Recommendation Report for Planning Permission for Works or Extension to a Dwelling

REF NO: LU/269/18/HH

LOCATION: 110 Southfields Road
Littlehampton
BN17 6PD

PROPOSAL: Vehicular access & hardstanding to front garden.

REF LU/269/18/HH

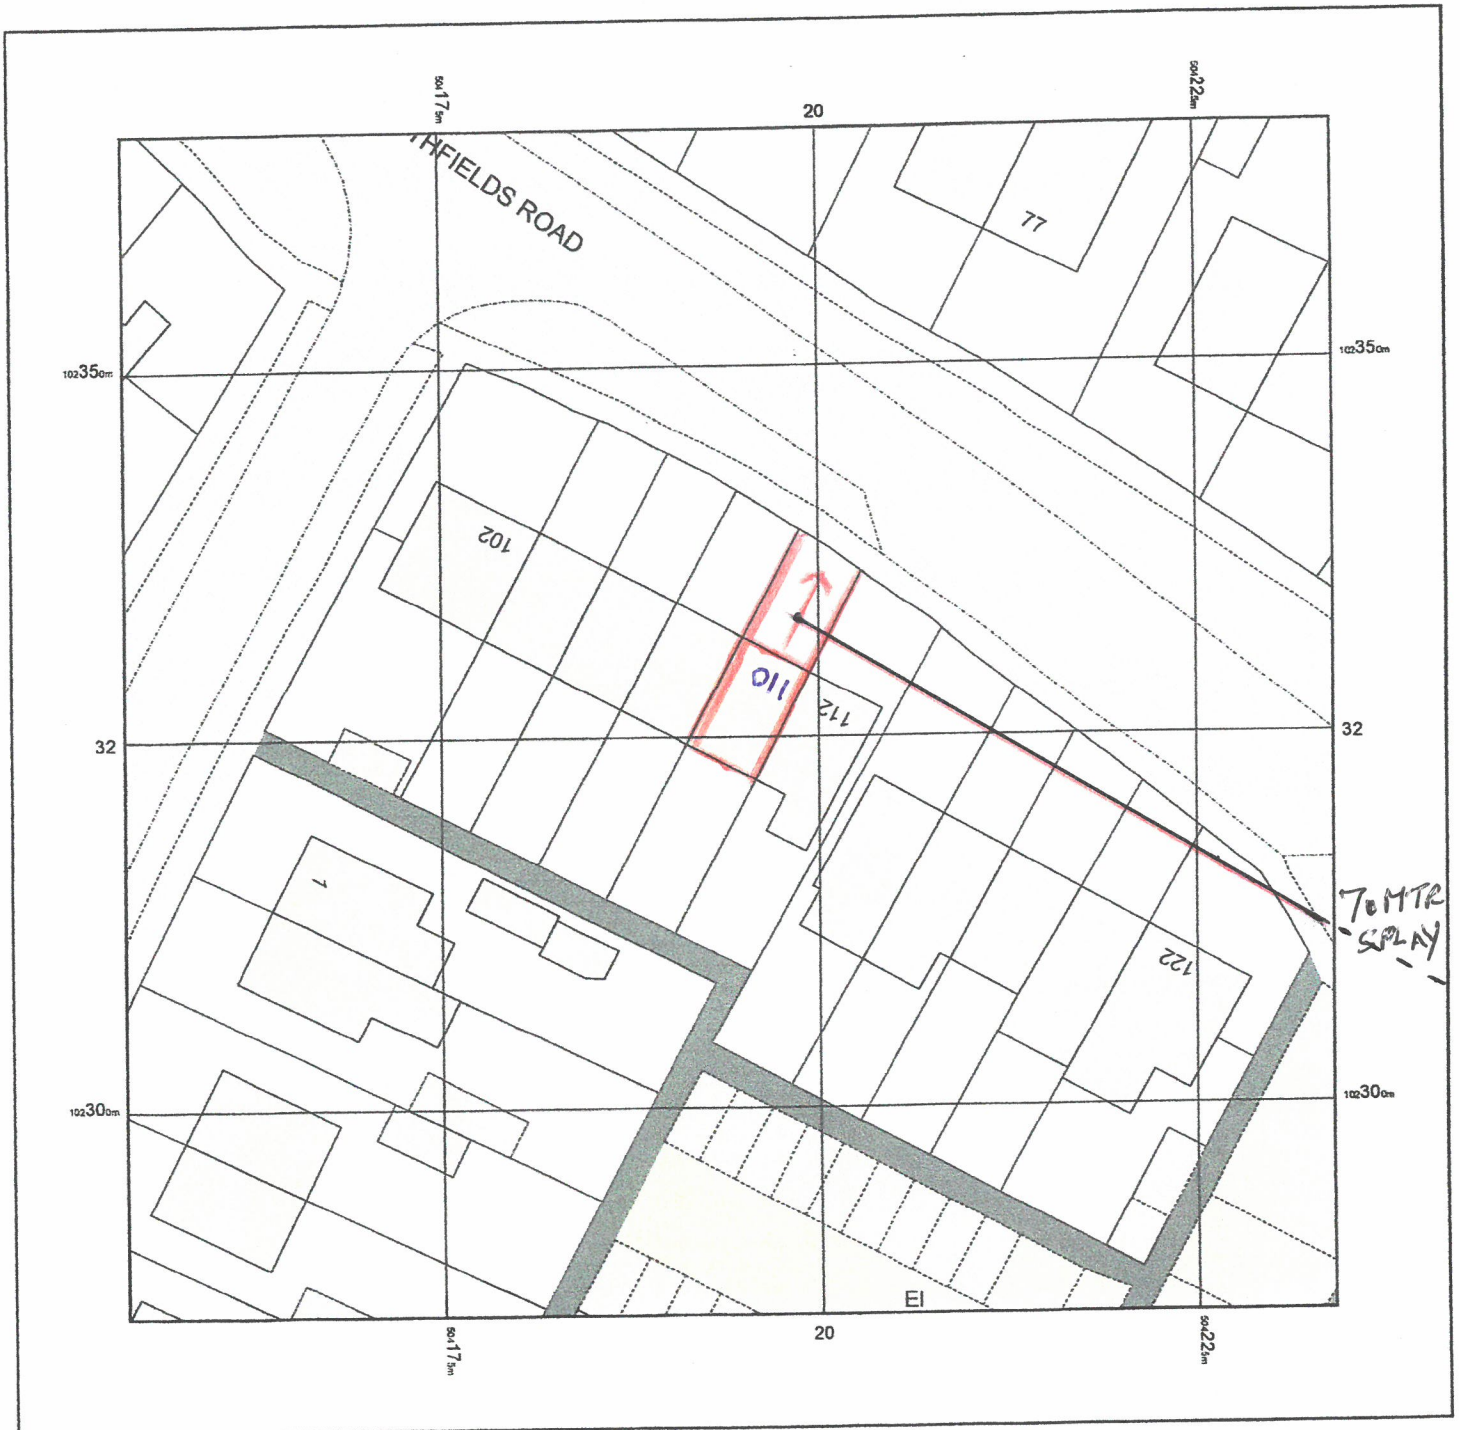
No detailed plans have been provided outlining any of the landscaping at the site however the LHA appreciate that there is space within the red edge to accommodate a vehicle off of the highway.

A condition is required to ensure plans outlining adequate space for within the hardstanding and curtilage of the site prior to occupation/use. The hardstanding is required to measure a minimum of 2.4 x 4.8m and be made up of a bound material on land within the applicants' red edge, although it appears that the entire frontage is to be surfaced to allow parking.

Visibility has been drawn incorrectly. Splays should be drawn from the back edge of the kerb and span from 2.4m back into the access. From observation of WSCC Mapping, the verge and footway at this point measures in excess of 2.4m and the splays are obtainable wholly within the highway boundary. Therefore visibility is not required to be conditioned alongside this application.

- 4 INFORMATIVE: The applicant is advised that the hardstanding should be finished with a permeable material or a soakaway shall be incorporated into the design to allow for adequate water run off.
